Please ask for: Nicola Moore
Email: nicola.moore@arun.gov.uk
Telephone: Ext 37944
Our Ref: A/166/21/T
Your Ref:
Date: 11th August 2021

Application for Works to Trees(s) subject to a Tree Preservation Order(TPO)

Development: Remove large branch of 1 No. London Plan tree (T54) approx 3m above ground level leaning towards neighbouring property.
Location: Land Adj To 12 Quiet Waters Close Angmering BN16 4DG

PROJECT	Quail Waters, Roundstone Lane, Acropora
TITLE	Detained Land-zipco Proposals

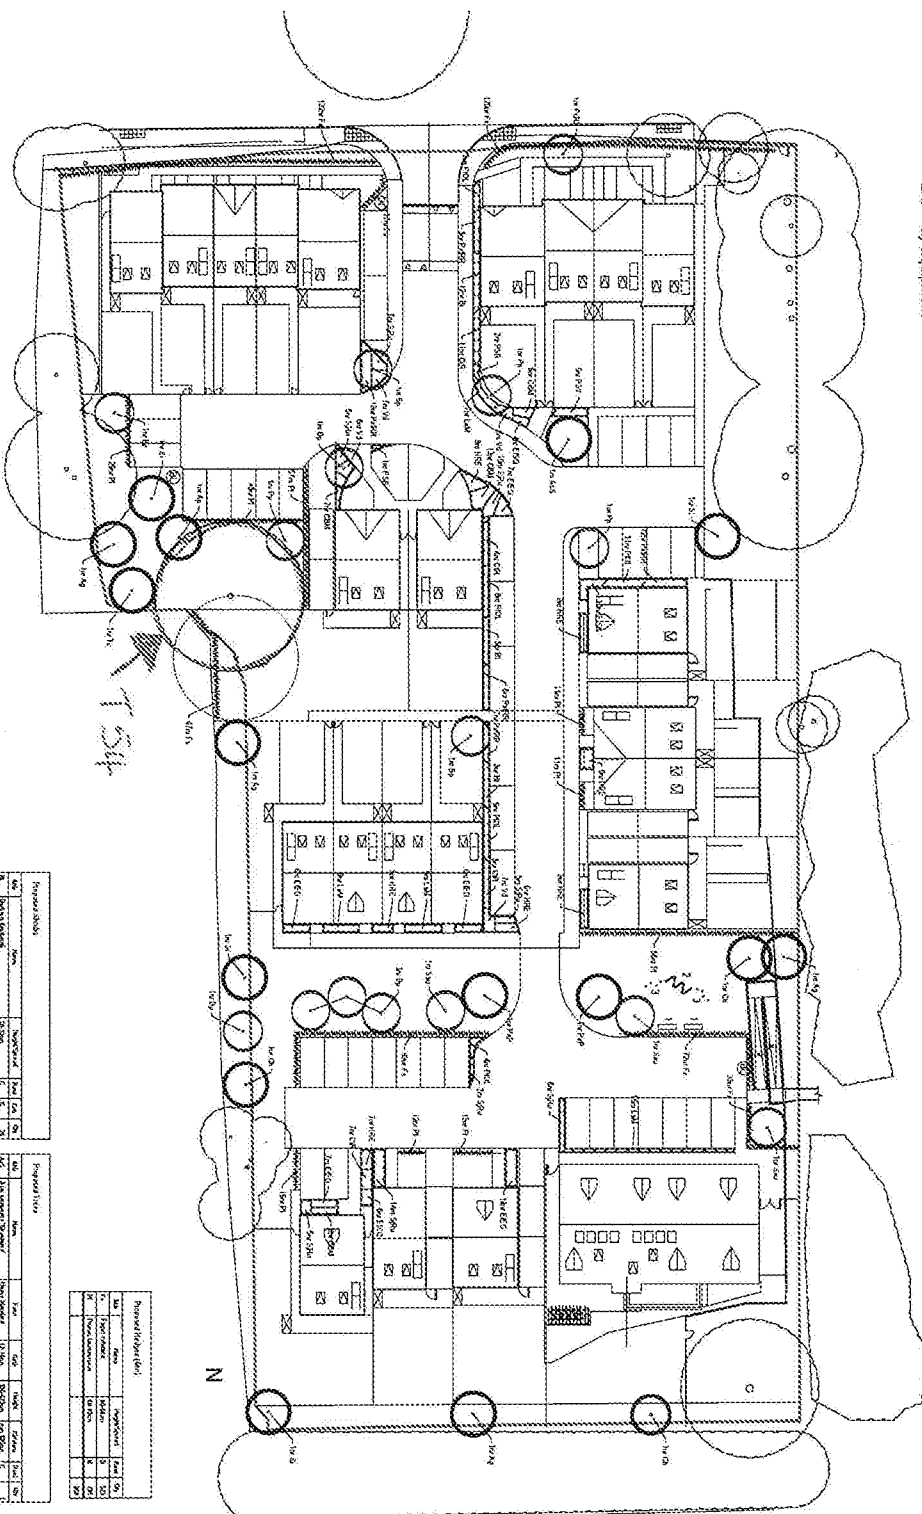
The sketch/location plan should include road names. Please amend accordingly and re submit.
As you have ticked yes in Section 8 regarding the condition of the tree, you are required to provide written arboricultural advise or other diagnostic information from an appropriate expert.
